Your ref: 3/2020/0763

Date: 15th January 2021

Application 3/2020/0763: Application for listed building consent to undertake structural and damp repair works to the building, insertion of replacement windows (like for like), replacement of roof coverings and the erection of new rainwater goods.
20-22 Talbot Street, Chipping PR3 2QE

Title: **FLOOR PLANS AND SECTIONS PROPOSED LAYOUT**

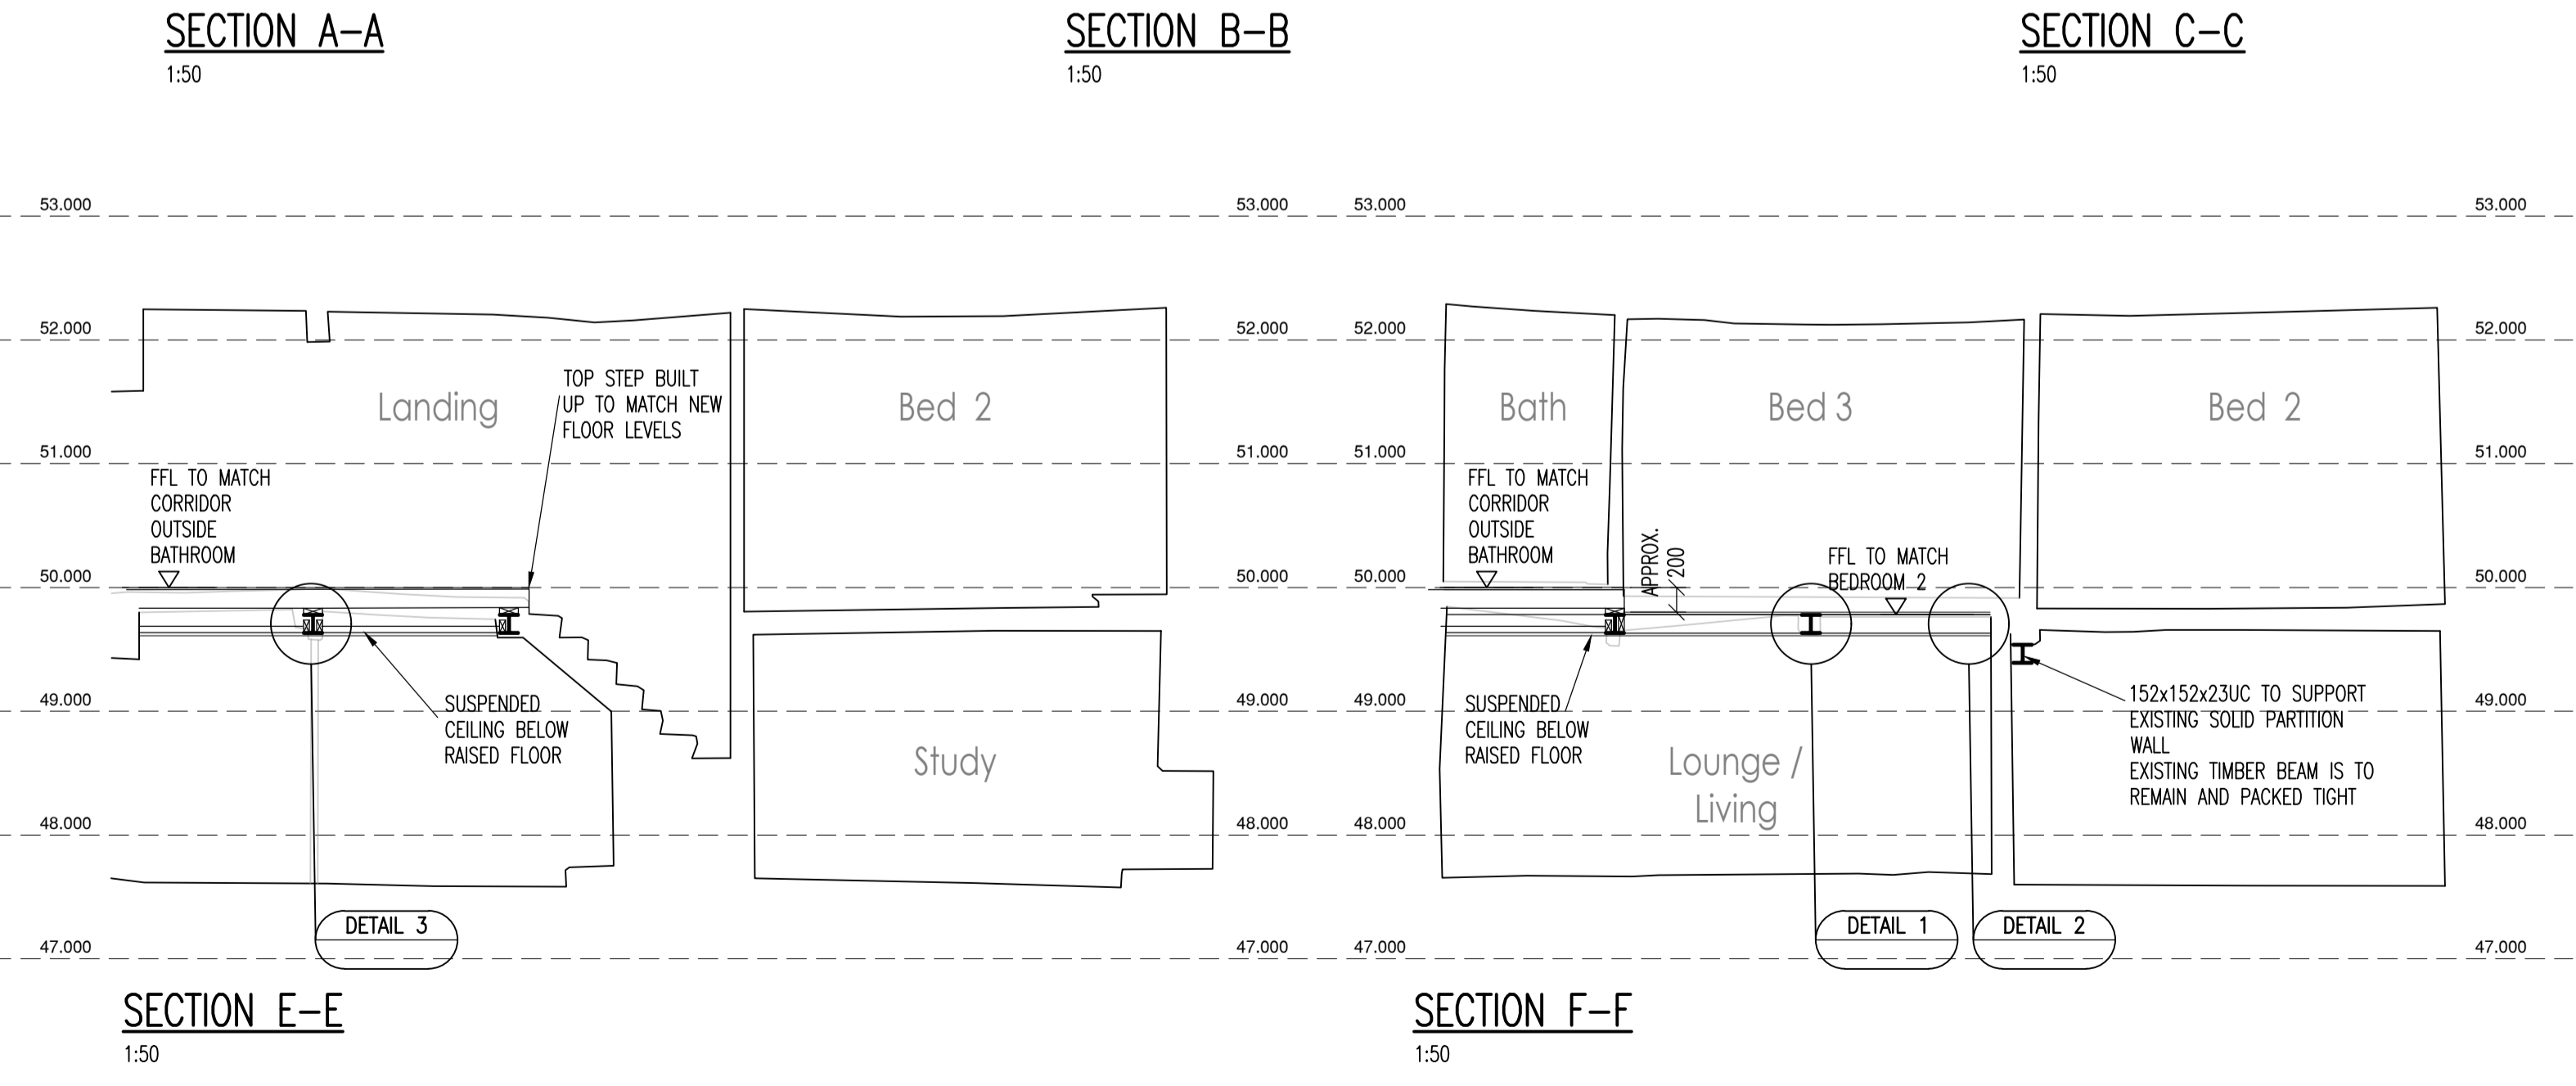
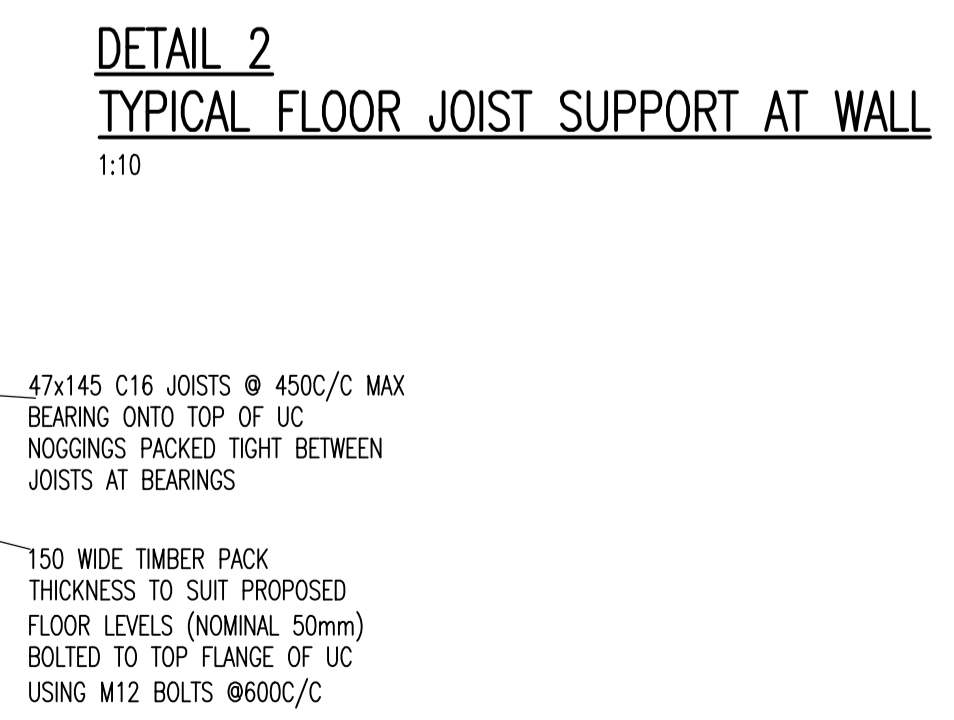
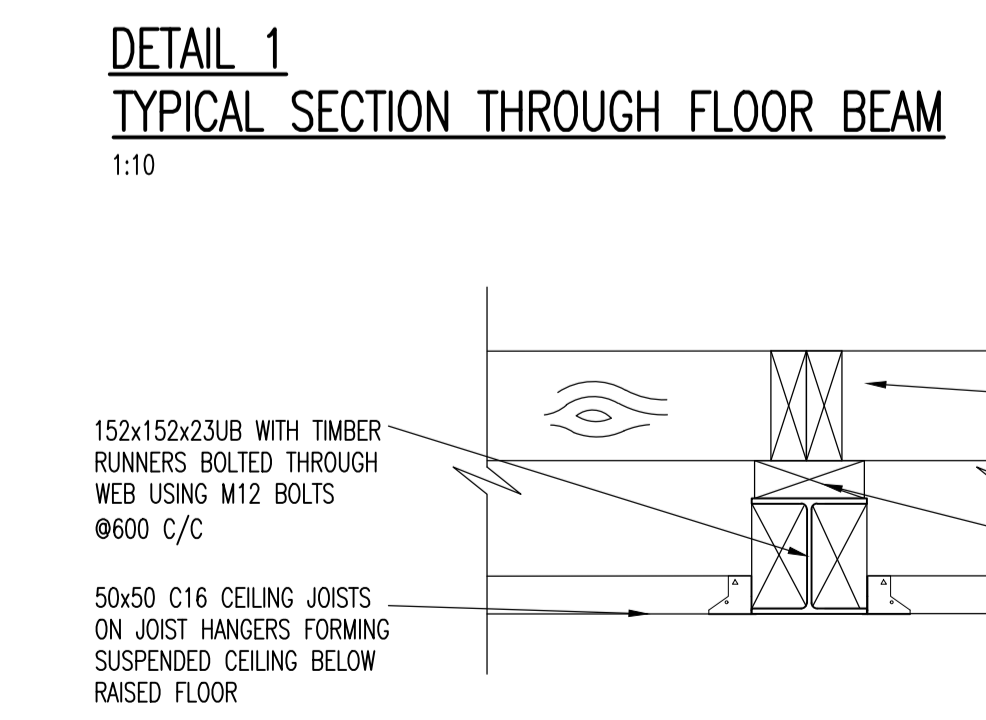
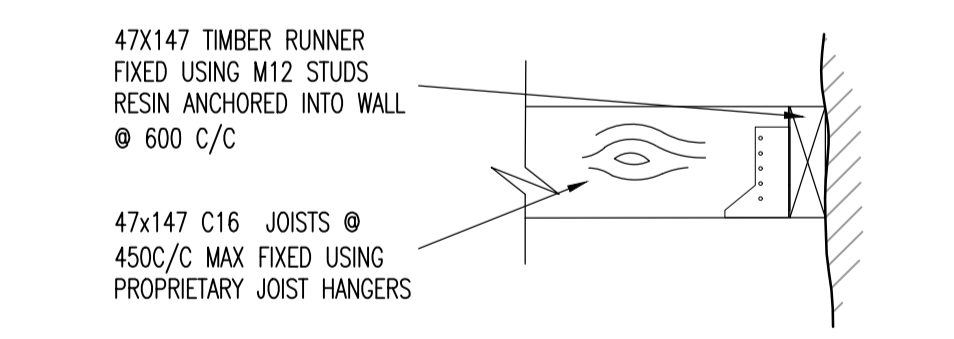
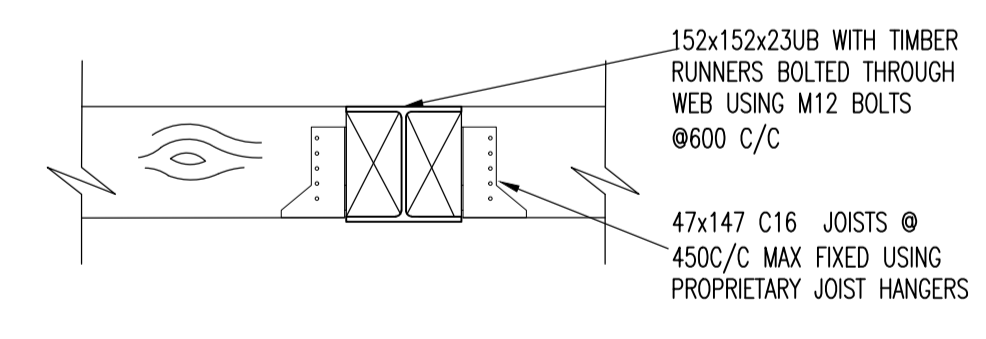
Thank you for your consultation on the above application. This is a particularly important building, as indicated by its designation as Grade II* Listed. The most significant work from our point of view is the reconstruction of the first floor above the lounge/living room. It has been well-justified however and we would not object to the works. It would seem appropriate, however, for a record of the present floor structure to be made, and it is suggested that this is done photographically at stages before and during the works.

It may also be worth considering if the timbers to be removed will be suitable for dating by means of dendrochronology. If this can be done with reasonable accuracy (which depends upon a number of factors, including the survival of the at least the heartwood/sapwood boundary) then it may provide further information about the house. For example is the datestone on the front of the building actually when it was built? – such stones are not always a good indication of construction date and may instead give the date of alterations, a change of ownership or an important event such as inheritance or marriage. We have alerted a member of the Historic England scientific dating team to the application and they may contact you directly about this.

If you also consider that a record of the floor structure is justified, then this can be required by a suitable planning condition. The following wording is suggested:

Condition: No works to the application building, including any clearance/demolition or preparation works shall take place until the applicant, or their agent or successors in title, has secured the implementation of a programme of photographic recording as set out in "*Understanding Historic Buildings*" (Historic England 2016). This must be carried out by an appropriately qualified and experienced professional contractor to the standards set out by the

Chartered Institute for Archaeologists and in accordance with a written scheme of investigation, which shall first have been submitted to and agreed in writing by the Local Planning Authority.
